**Addendum No. 1**

RE: Contract ID C203801

**Ashe County (R-2915C)**

US-221 From North Of South Fork New River To South of NC-194

SHEET NO. W-3

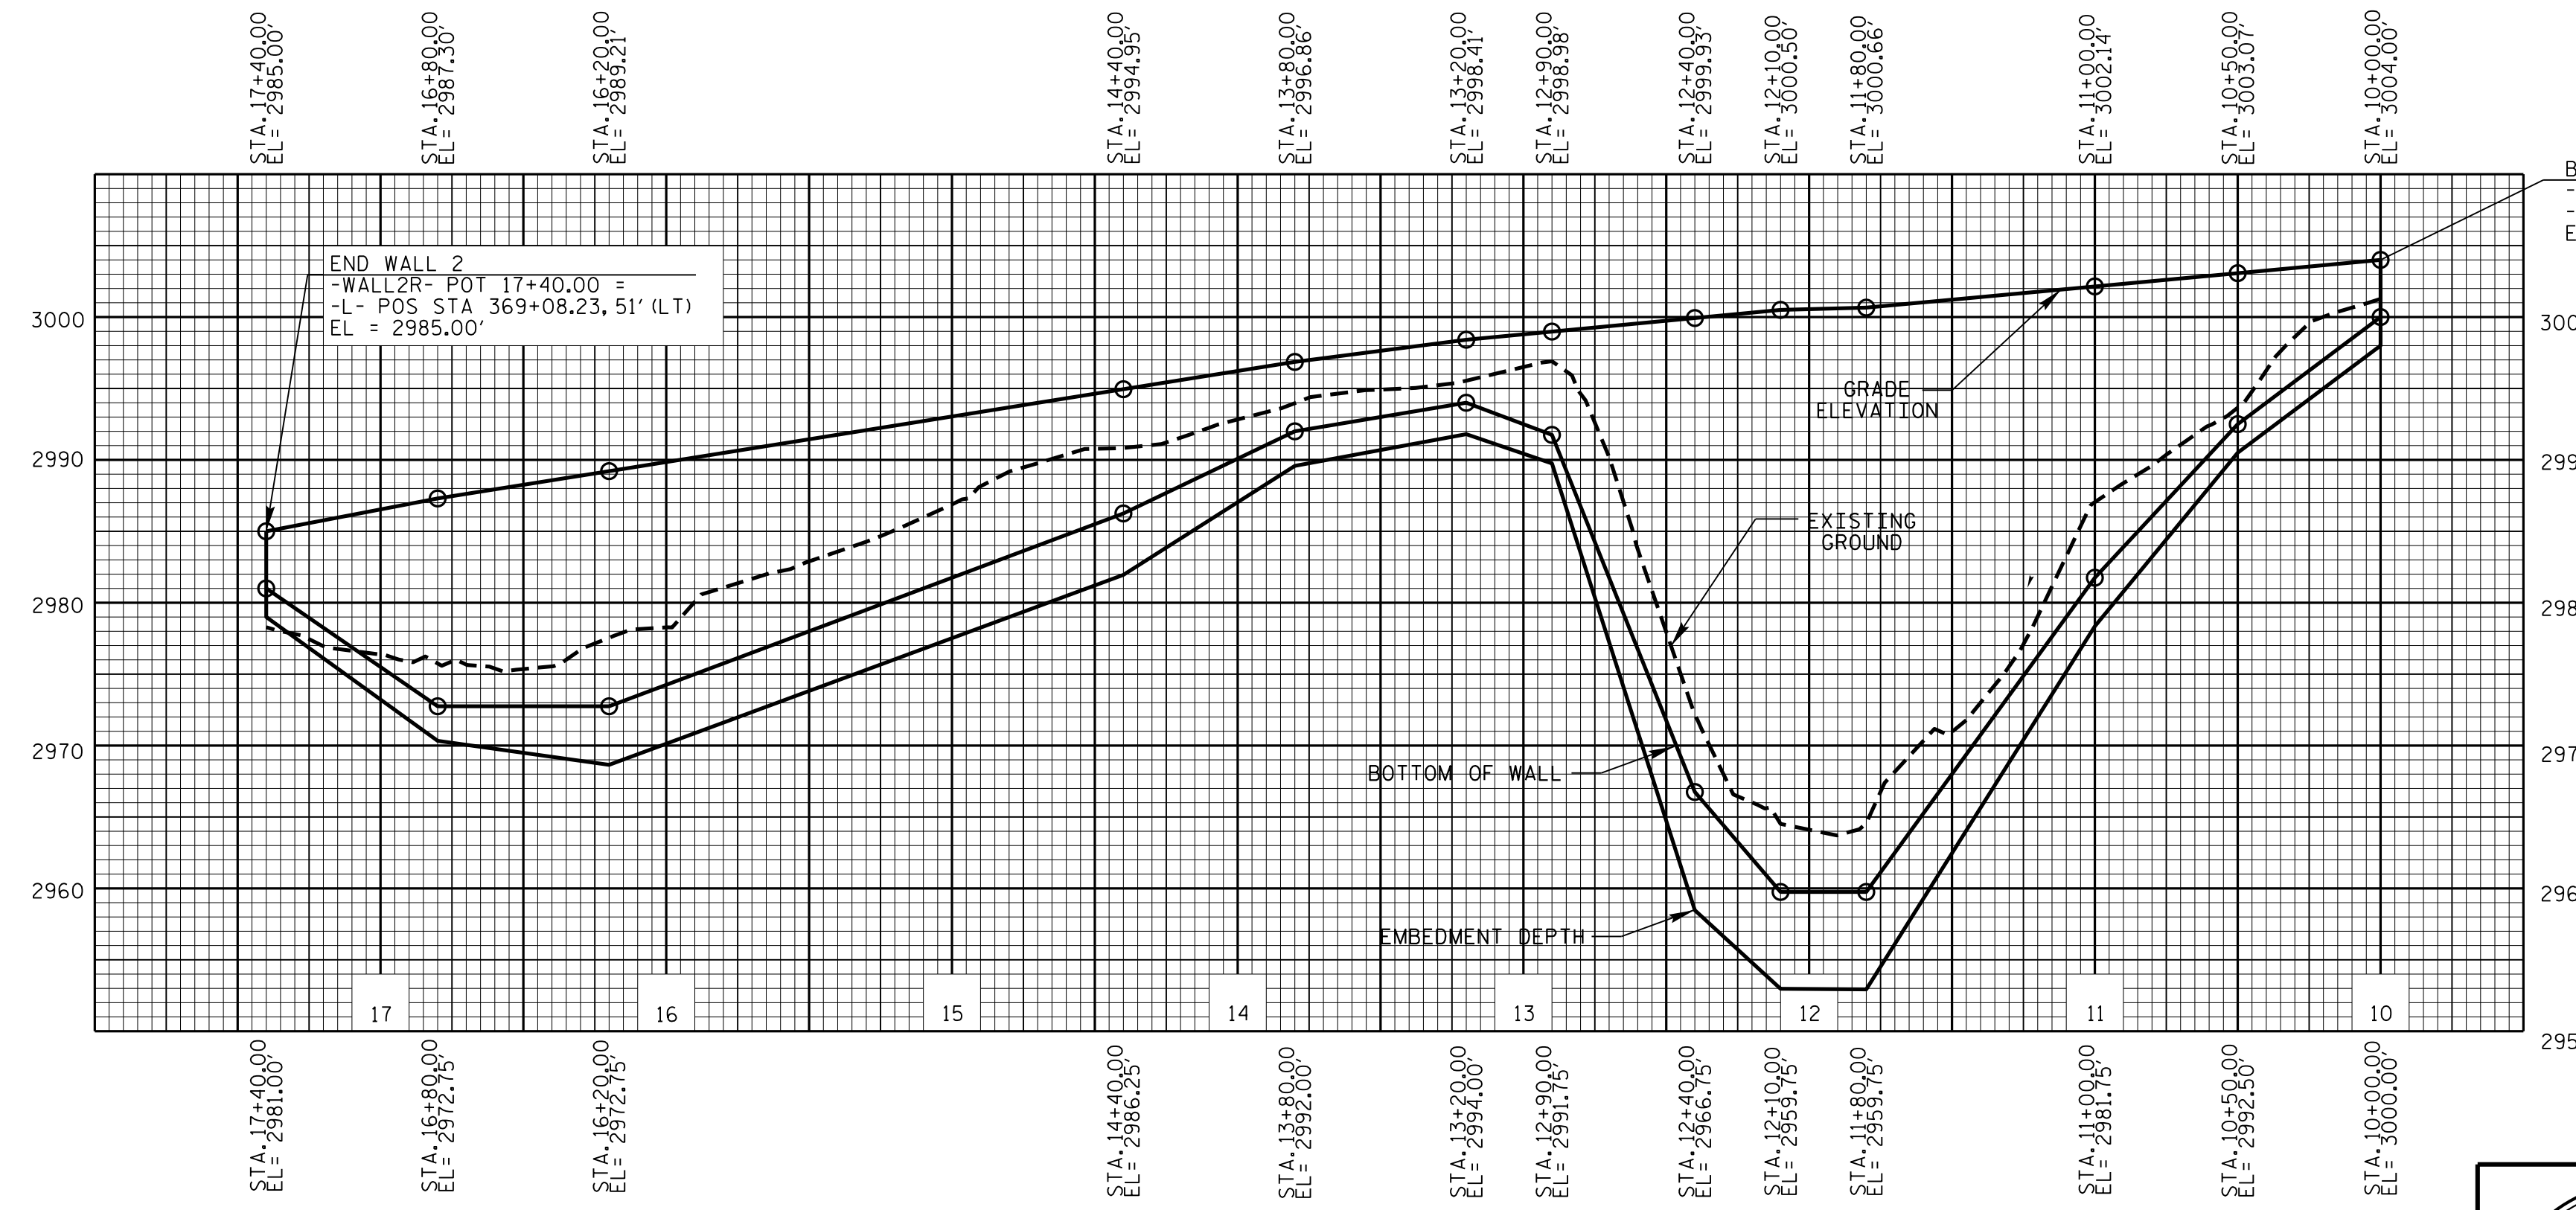
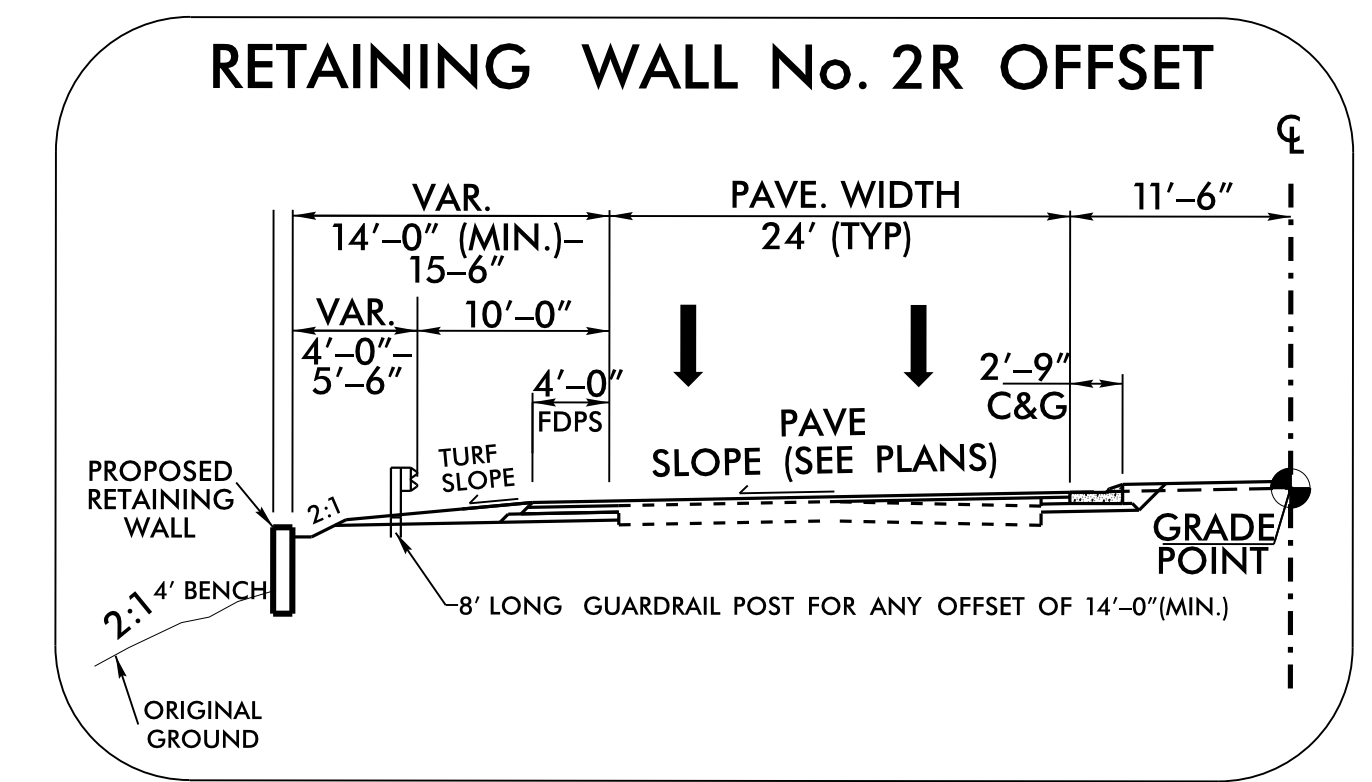
Sheet No.	Revisions
W-3	Revised to add a table with offsets for Wall No. 2
